From: Biazar, Shahab <sbiazar@cabq.gov>
Sent: Thursday, May 05, 2016 3:21 PM
To: Yolanda Padilla Moyer
Cc: Kevin Patton (Kevin.Patton@PulteGroup.com); Abiel X. Carrillo; Harmon Rita T.
Subject: RE: Pulte Traditional Phase 2 Amended Preliminary Plat
Attachments: 20160103_OverallGrading_amend.pdf

From: Yolanda Padilla Moyer [mailto:ypadilla@bhinc.com]
Sent: Thursday, May 05, 2016 3:07 PM
To: Biazar, Shahab
Cc: Kevin Patton (Kevin.Patton@PulteGroup.com)
Subject: Pulte Traditional Phase 2 Amended Preliminary Plat

Drawing file: Plans / 8_20160103_OverallGrading_amend.pdf

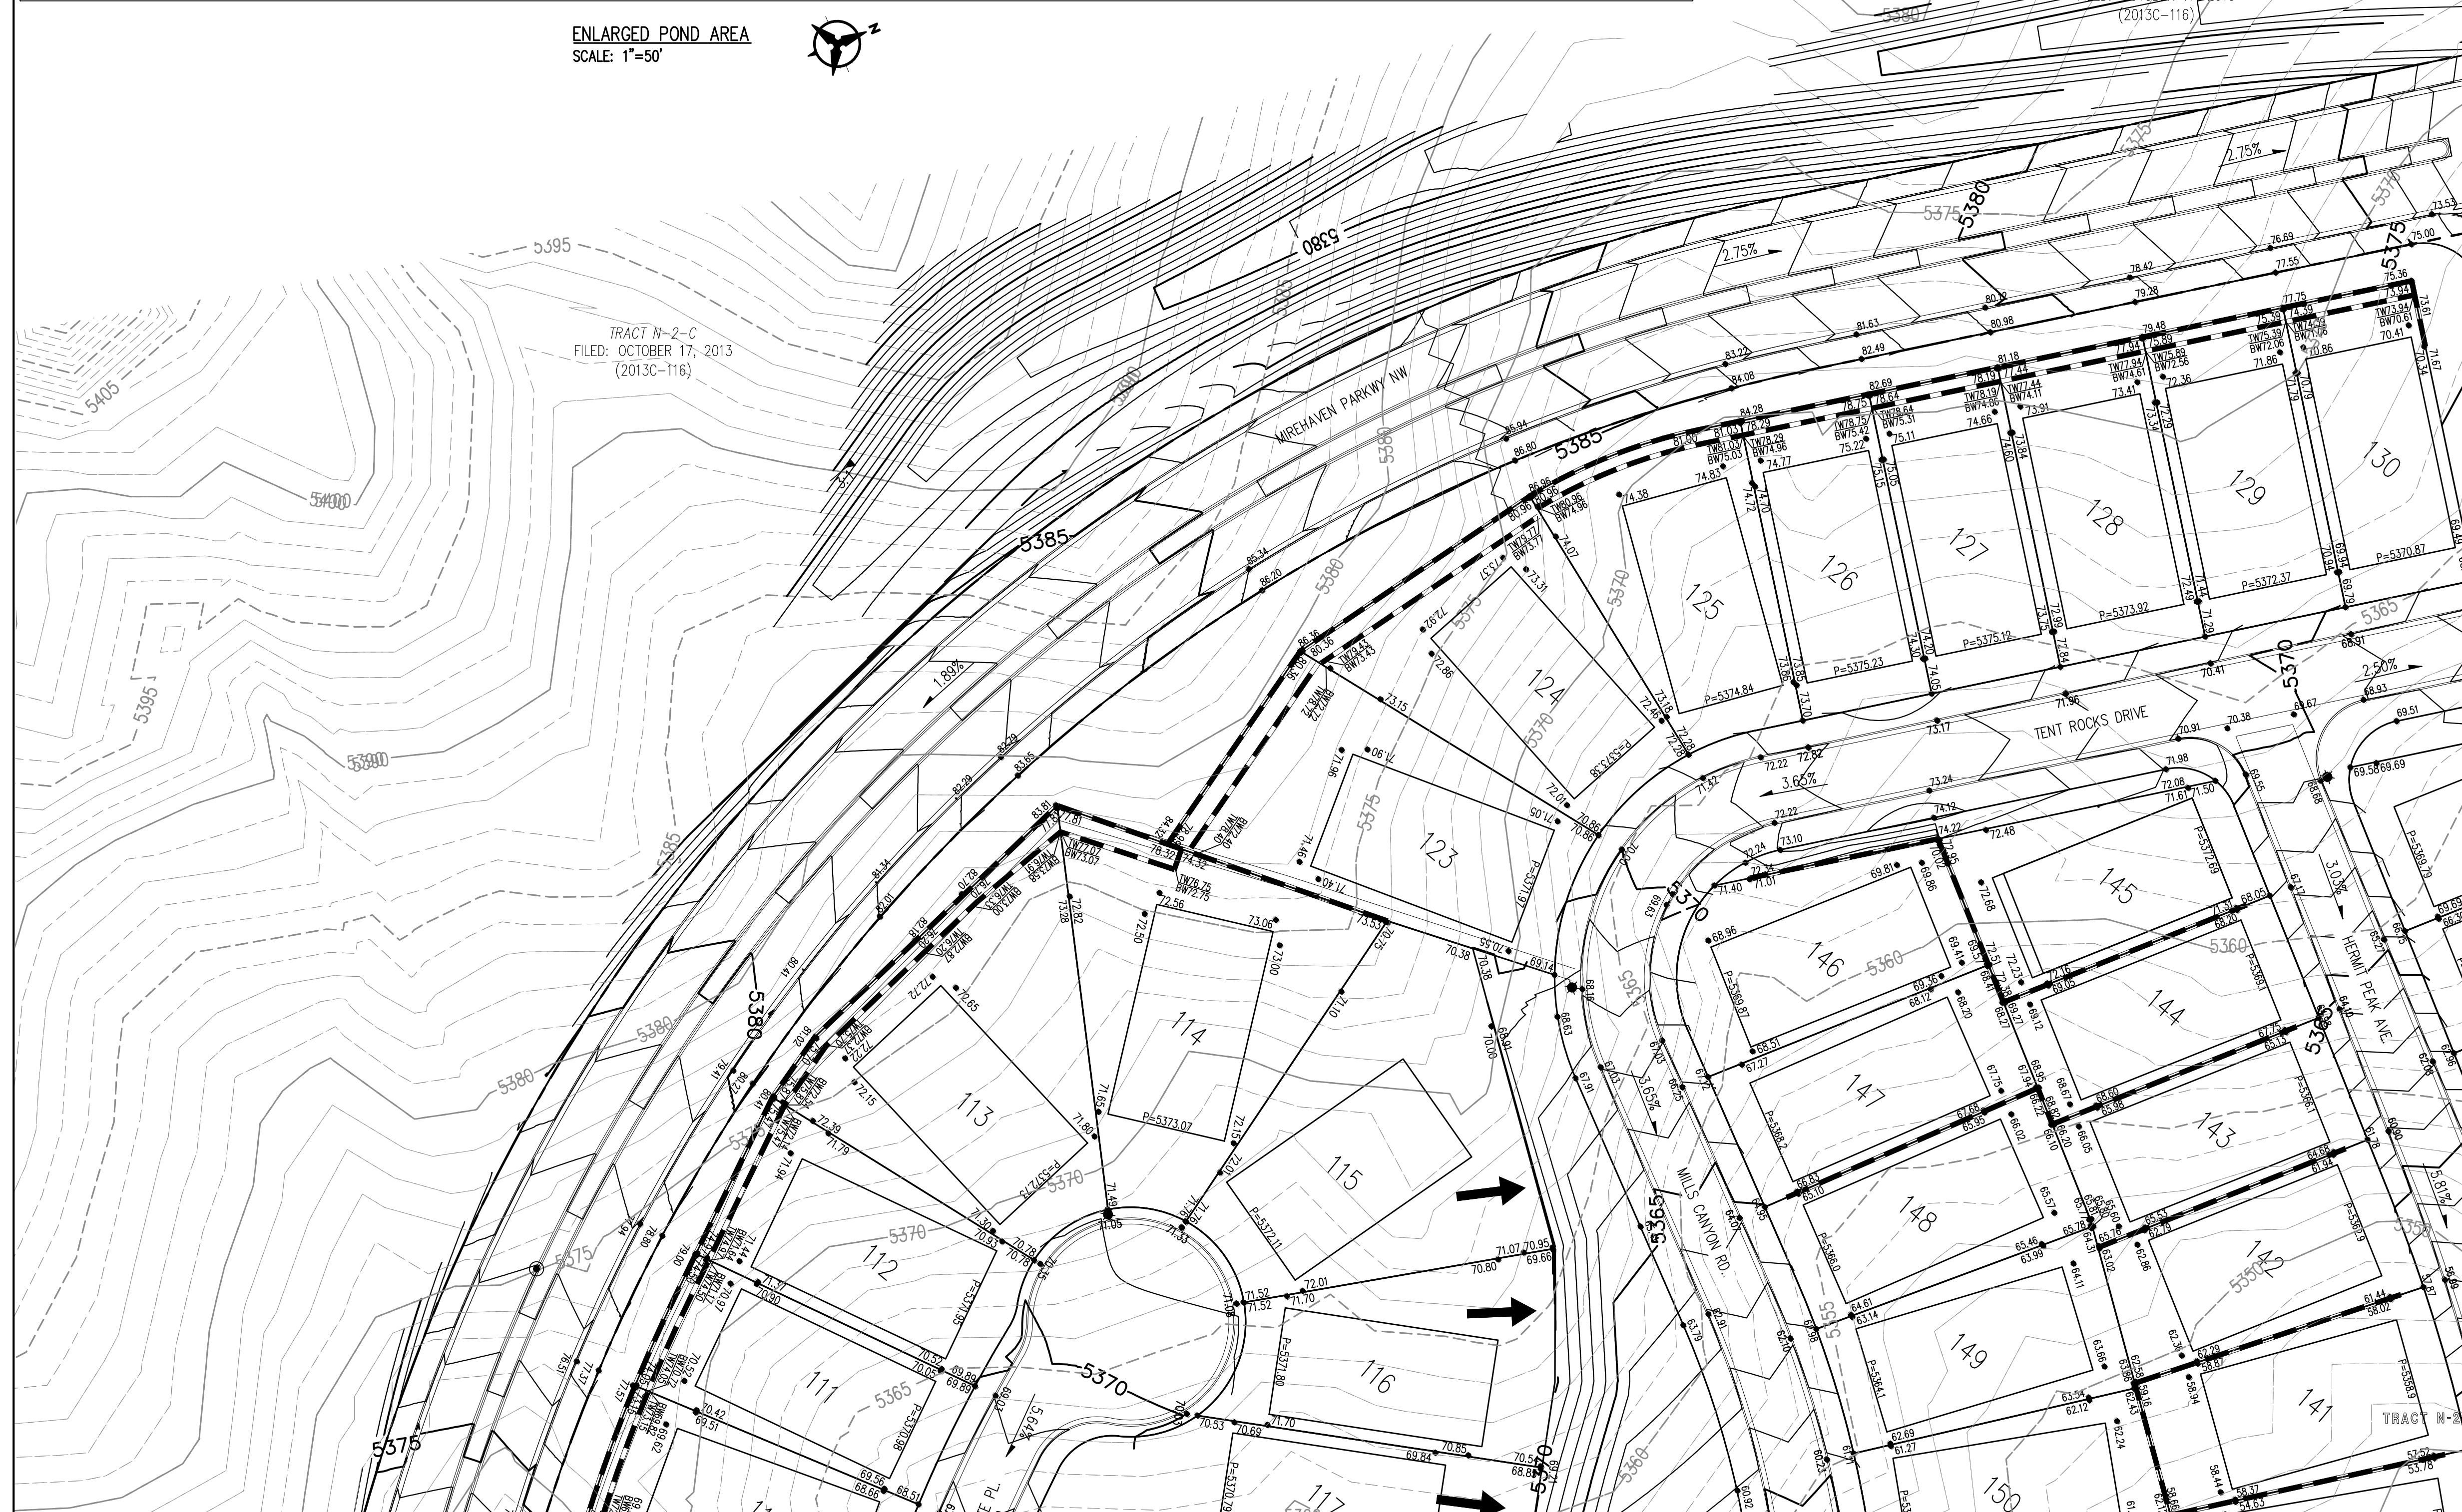
Per our phone conversation, enclosed is an exhibit which shows the area where the back lot lines are shifting approximately 5' to take access area in the lot and add it the HOA Tracts behind the lots adjacent to Mirehaven Parkway and Tierra Pintada. The grading and drainage for these lots and areas will not be effected by the shift and will not change. We will asbuilt any changes on the Grading and Drainage Certification.

Since there is no change in the drainage pattern nor the grading/retaining wall heights, the shift in the back yards can be shown as part of the final certification of the grades. A new grading plan submittal will not be required.

You can move forward with your preliminary plat submittal to amend the lot line changes.
